# CITY OF ALBUQUERQUE

Re: Commercial Self-Storage, Engineer's Stamp dated 5-1-07, (C18/D37G)  
Lot 30 Block 9 Tract A Unit B of North Albuquerque

# CITY OF ALBUQUERQUE

Re: Commercial Self-Storage, Lot 30 Block 9 Tract A Unit B of North Albuquerque Acres  
Engineer's Stamp dated 7-5-06 (C18/D37G)

COMMERCIAL SELF STORAGE GRADING & DRAINAGE PLAN

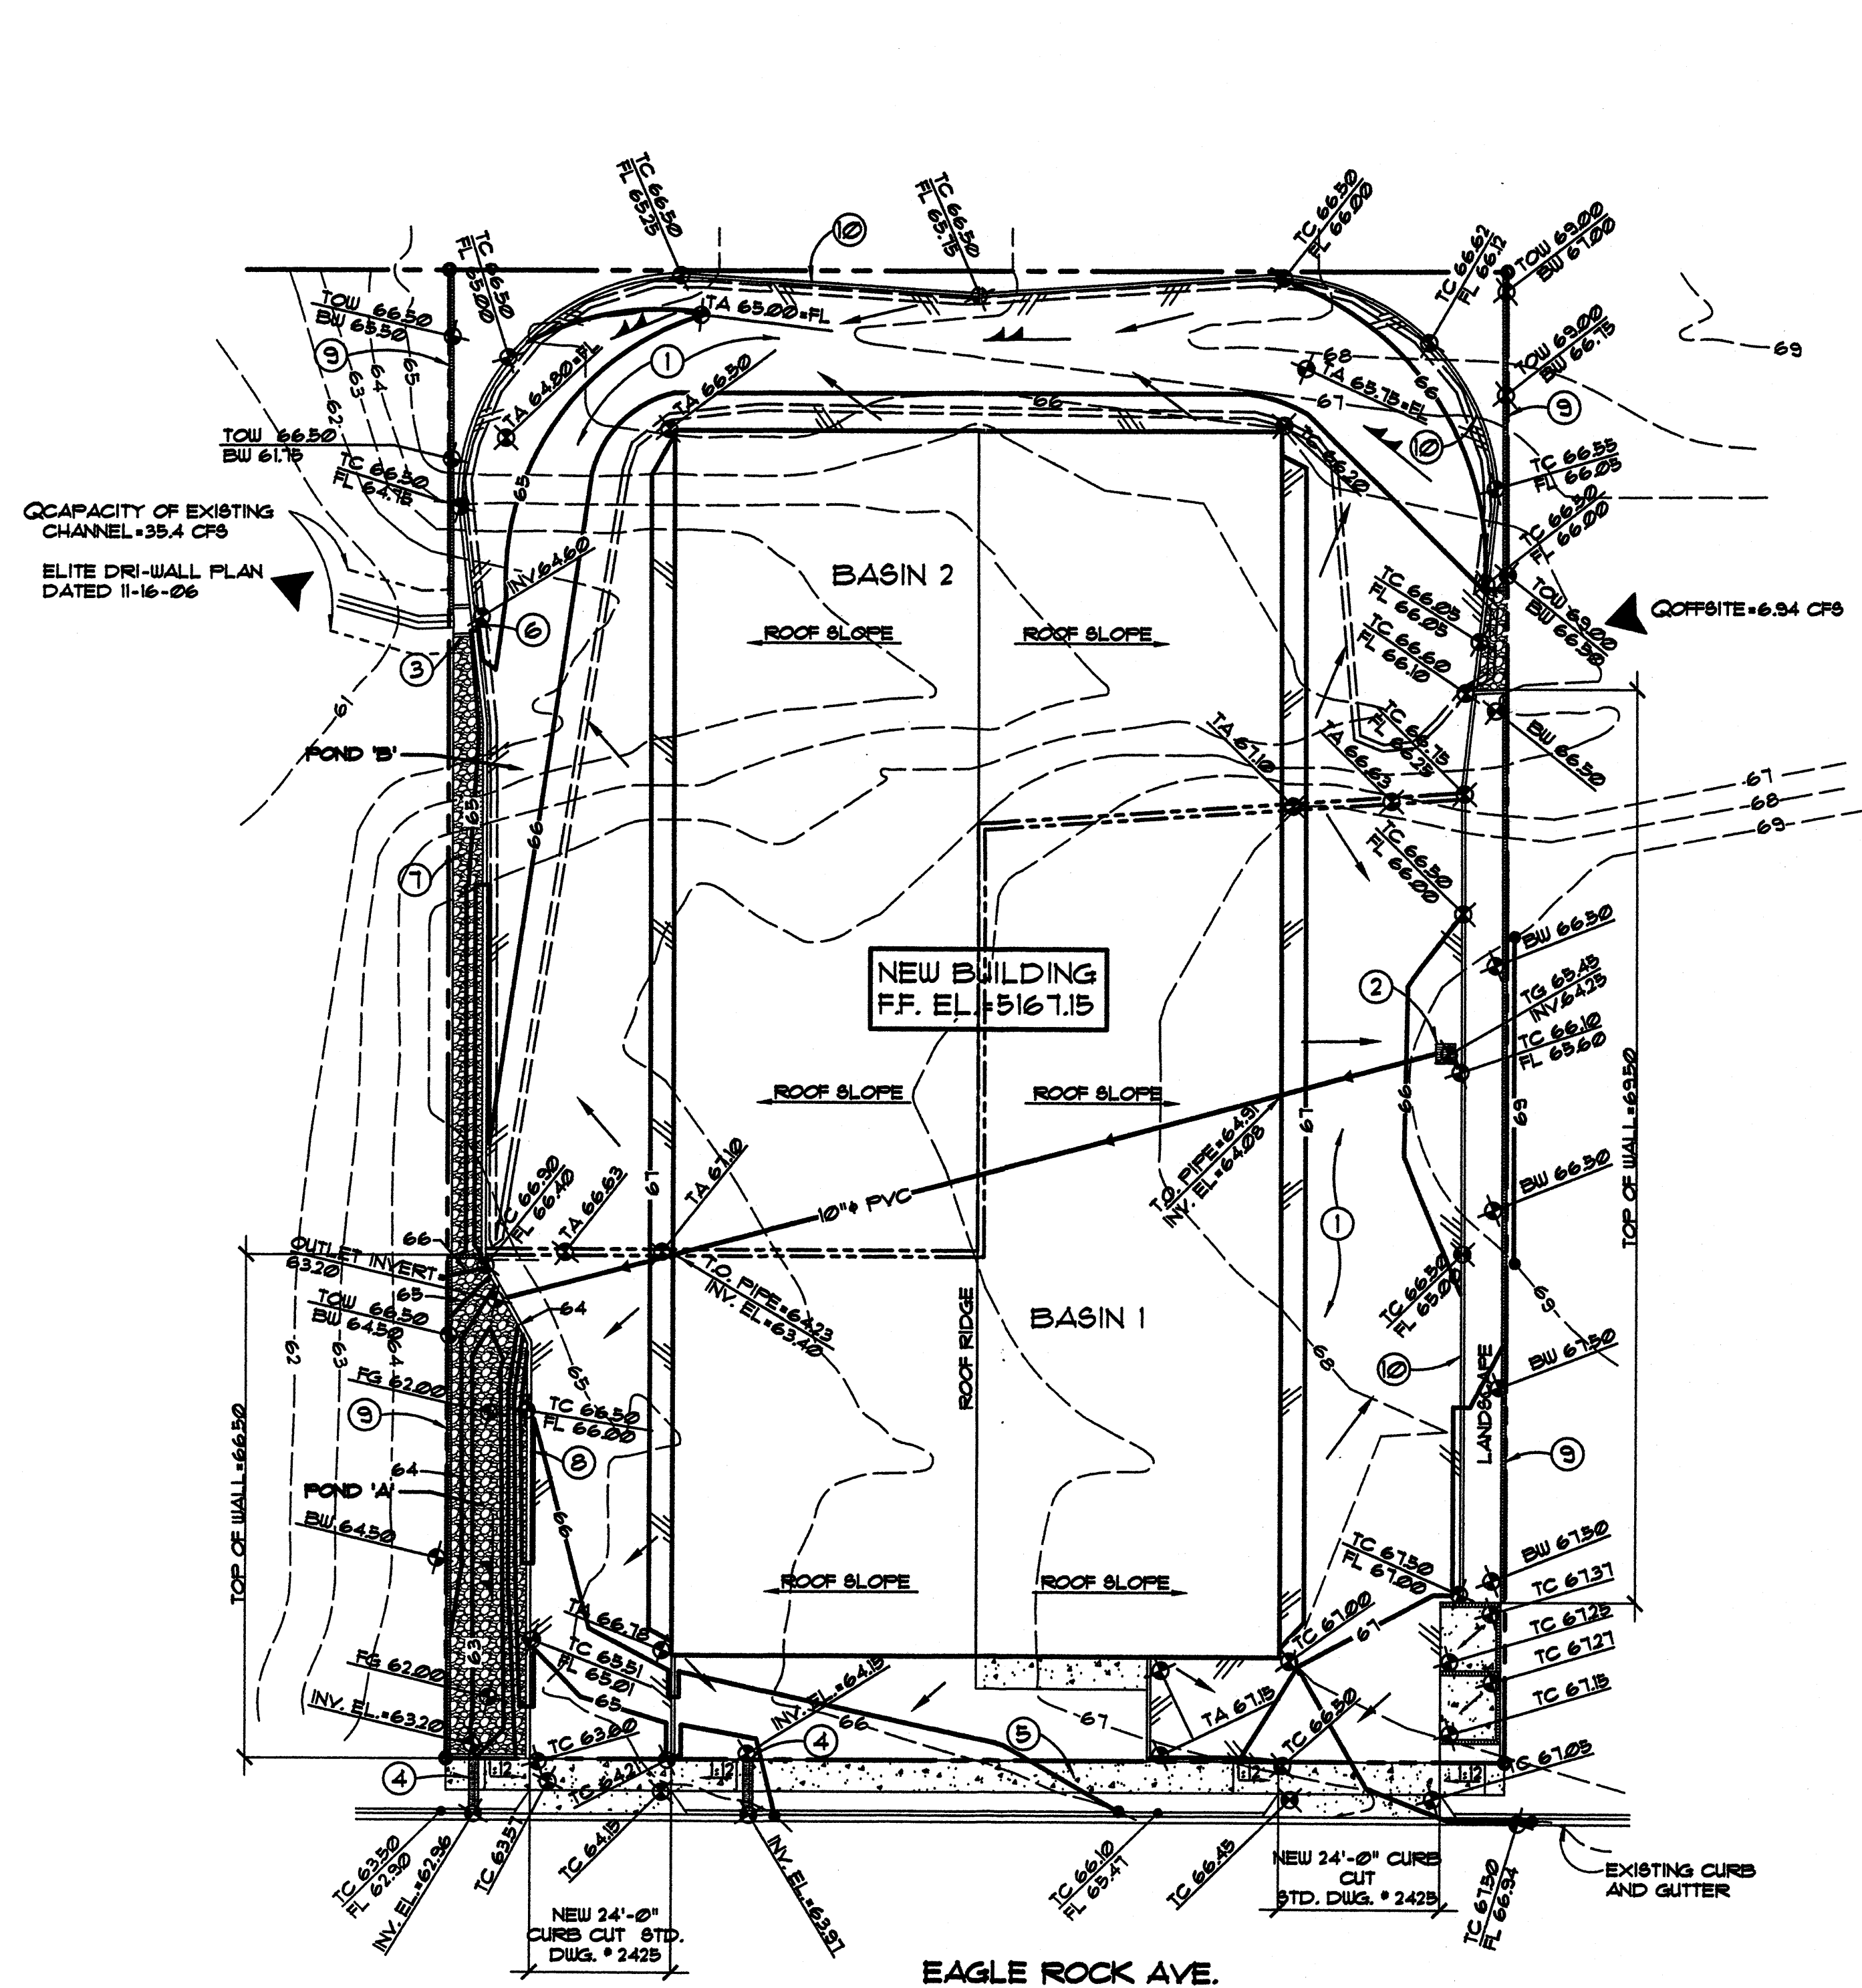
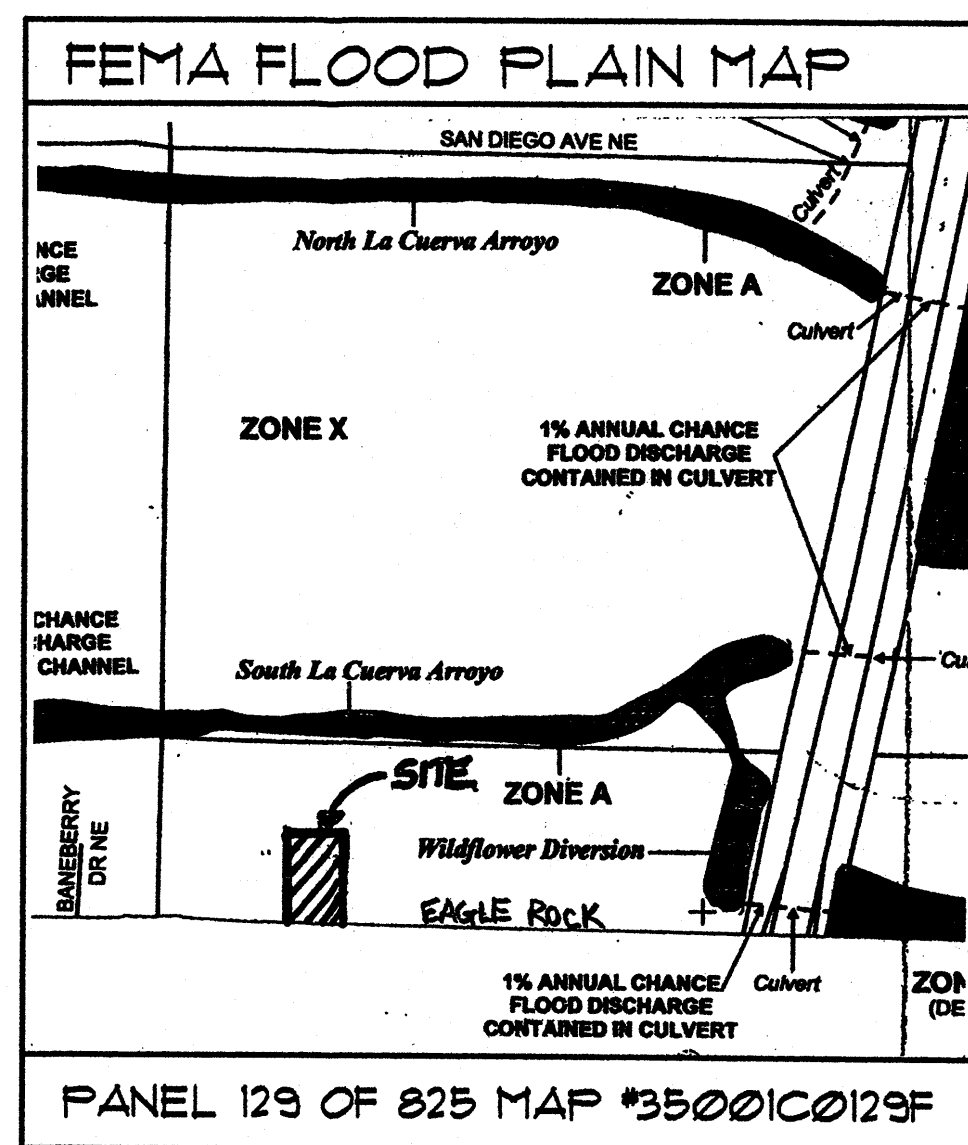
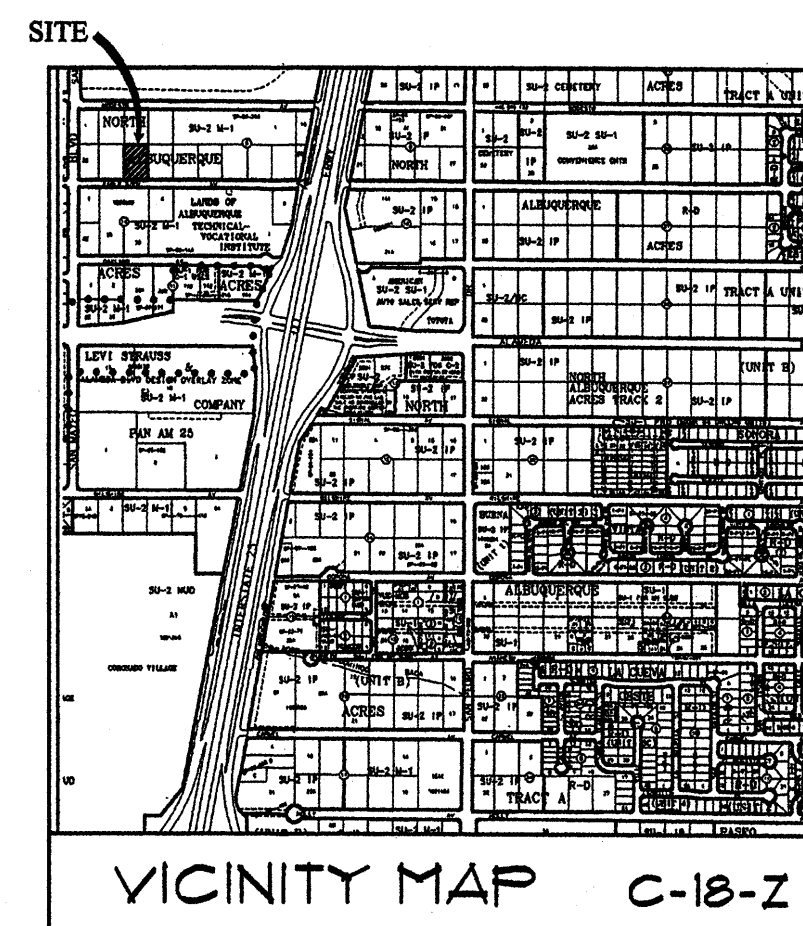
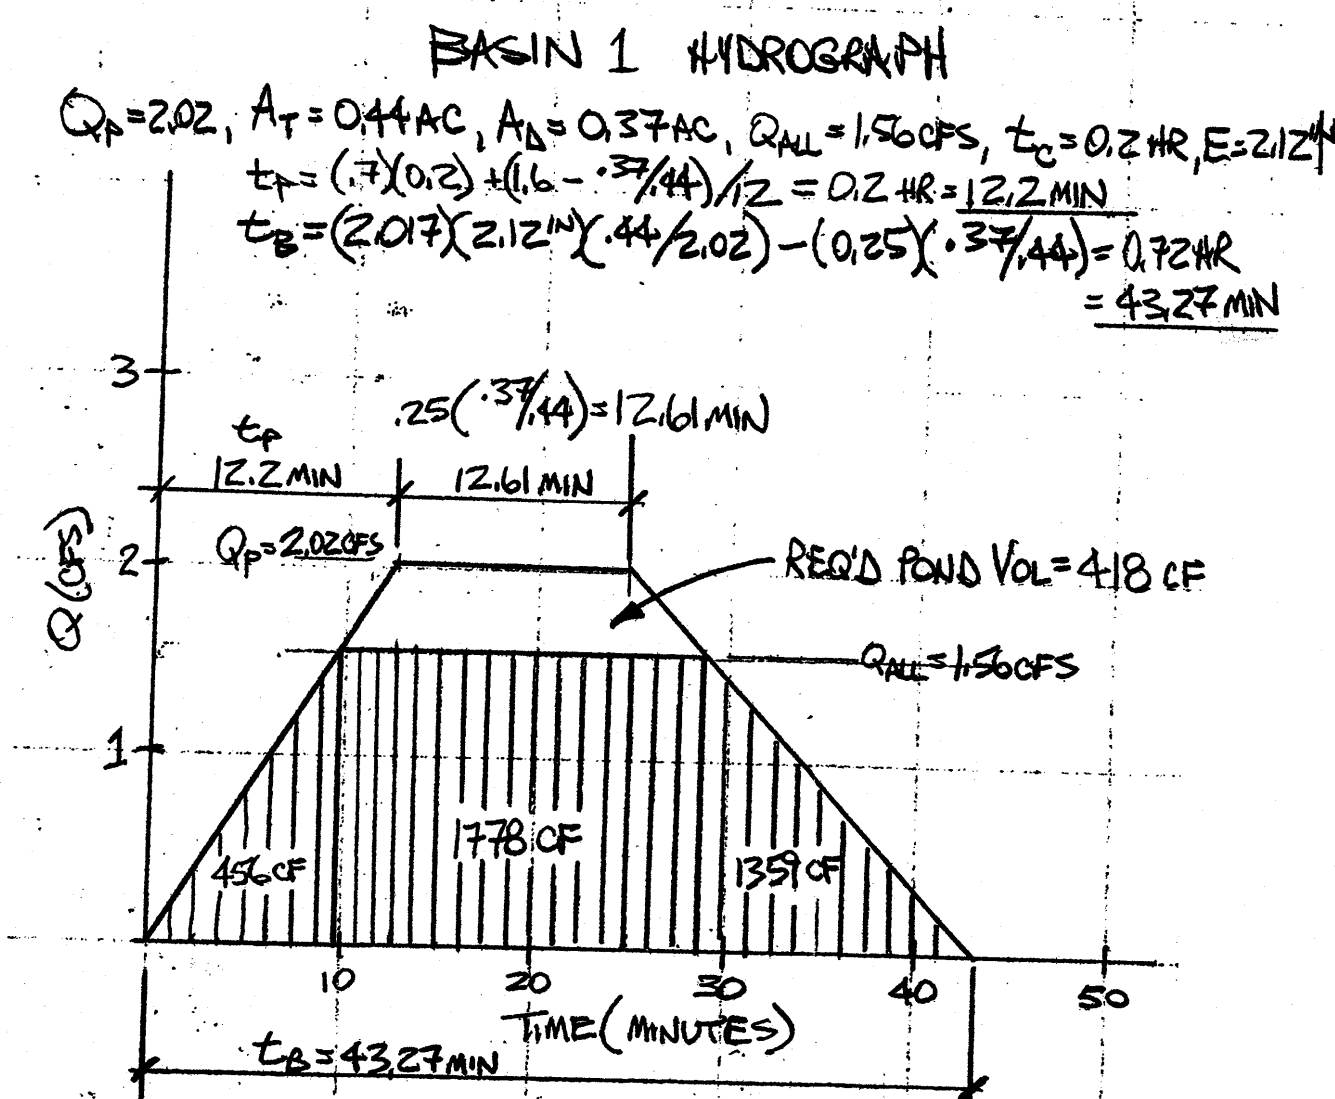
Based on the information contained in your submittal received on April 10, 2007, I am concerned about the proposed pond volume of 472 ft<sup>3</sup>. The Master Plan does allow for undeveloped flows to progress westward across lot lines. The remainder of the flow is intended to discharge to Eagle Rock at no more than 1.7 cfs/acre or 1.56 cfs for the 0.89-acre site. In this case, with the 6.94 cfs offsite flow and your undeveloped flow of 1.66 cfs, the total flow across the western lot line will be limited to no more than 8.6 cfs. As such, not all of the proposed basin 2 water could drain to that discharge point.

My estimated calculations indicate that the pond volume required to comply with the 1.56 cfs limitation would be approximately 1,700 ft<sup>3</sup>. Since only 9-inches of depth was used, are the calculations for pond 'A' correct? Was this intended to represent a ponding area around the eastern (keyed note 2) drop inlet? How will the flow to the western lot be controlled? Please address this in your narrative and provide the necessary supporting calculations. Modification of the basin geometry may be necessary to route more flow into basin 1 and the pond.
